Subject: RE: Attached letter from Kirklees Council regarding application number 2025/93438 at location Arena Young Peoples Centre, Moorlands Road, Dewsbury, WF13 2LF

The wall in question is a retaining wall and as such any modifications to it will be liable to a formal technical approval, however, it may not require an AIP subject to the extent of the proposed works.

Bridges & Structures Manager
Structures Section
Highways and Streetscene
Kirklees Council

Site Section 2 to Boothroyd Lane

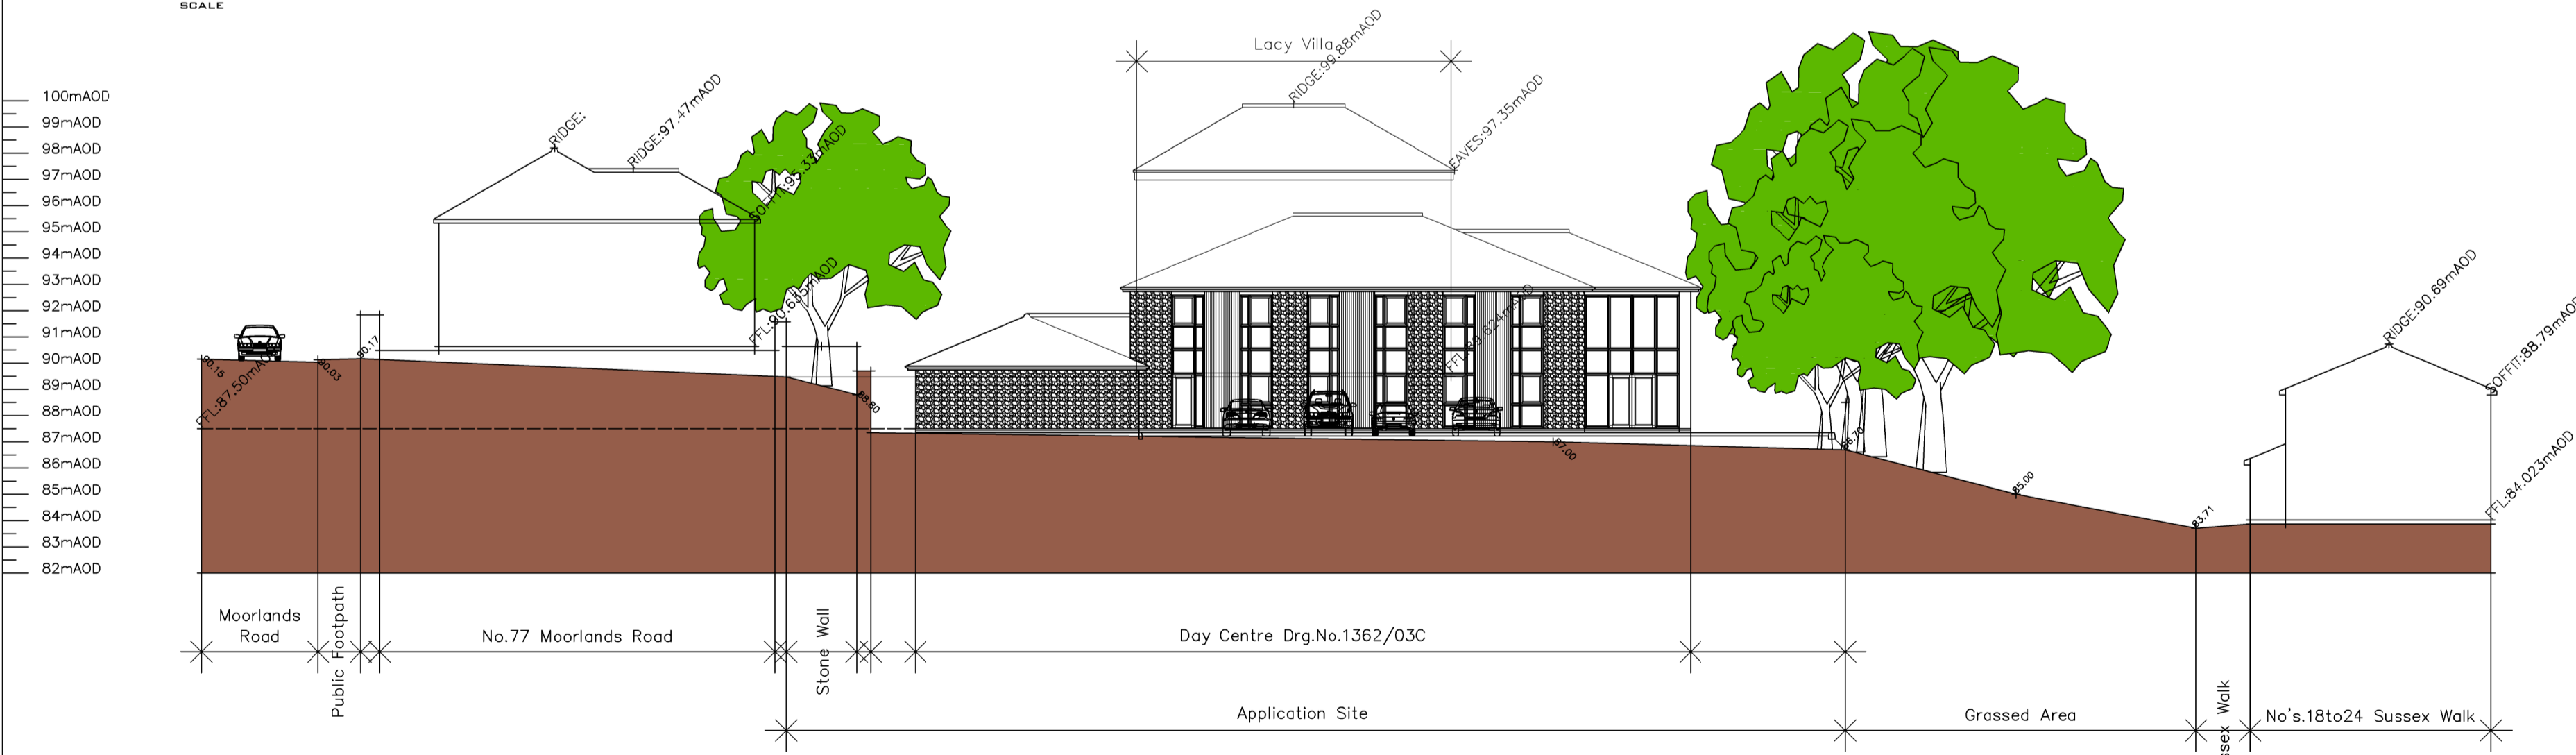
- 1) Before the development commences, the design of proposed retaining walls adjacent to the existing highway including any modification to the existing retaining wall adjacent to Boothroyd Lane shall be submitted (via submission of AIPs where applicable) and approved by the Highway Authority in writing. The approved scheme shall be implemented prior to the commencement of the proposed development and thereafter retained during the life of the development.
